Ribble Valley Borough Council  
Development Control

Application no: 3/2019/0896

Address: 89 Chatburn Road Clitheroe  
Proposal: Extensions to 89 Chatburn Road, Clitheroe

PROPOSED GROUND FLOOR PLAN

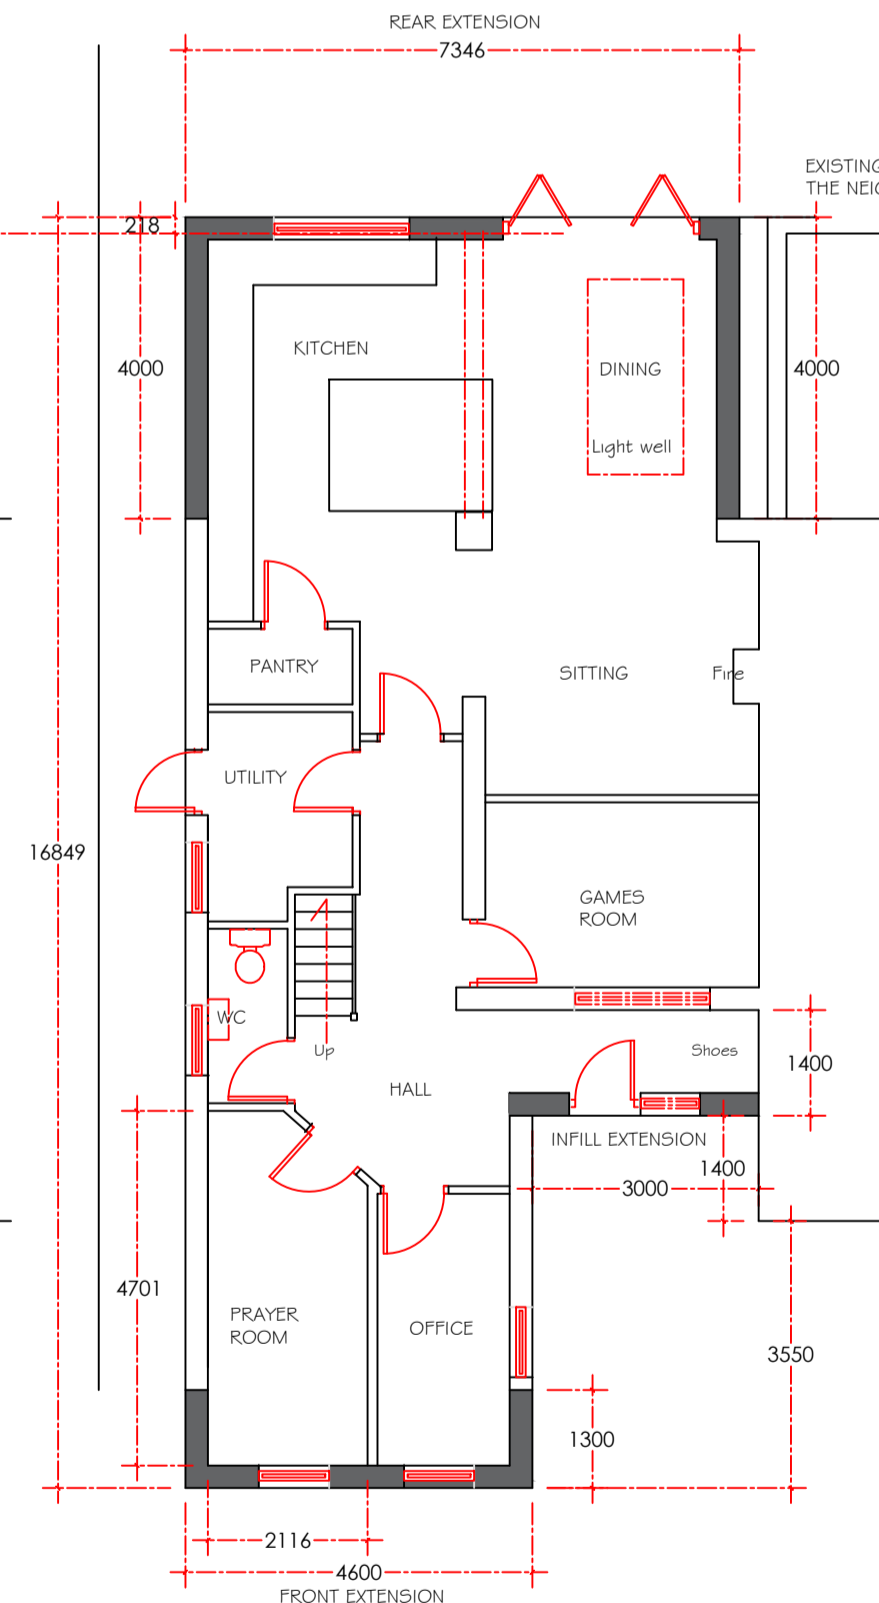
Whilst I would raise no objection to the proposal on highway grounds it is noted that the vehicular access has been widened to accommodate the additional parking area provided in the front garden. Whilst this is to be welcomed as it improves access into the property there has been no corresponding widening carried out on the vehicle access crossing therefore should your council be minded to approve this application I would be grateful if you could attach the following note.

This consent will require the alteration of an access to the public highway. Under the Highways Act 1980 Section 184 (Vehicle crossings over footways and verges), the County Council as Highway Authority must specify the works to be carried out, Only the Highway Authority or a contractor approved by the Highway Authority can carry out these works and therefore before any works can start you must complete the online quotation form found on Lancashire County Council's website using the A-Z search facility for vehicular crossings.
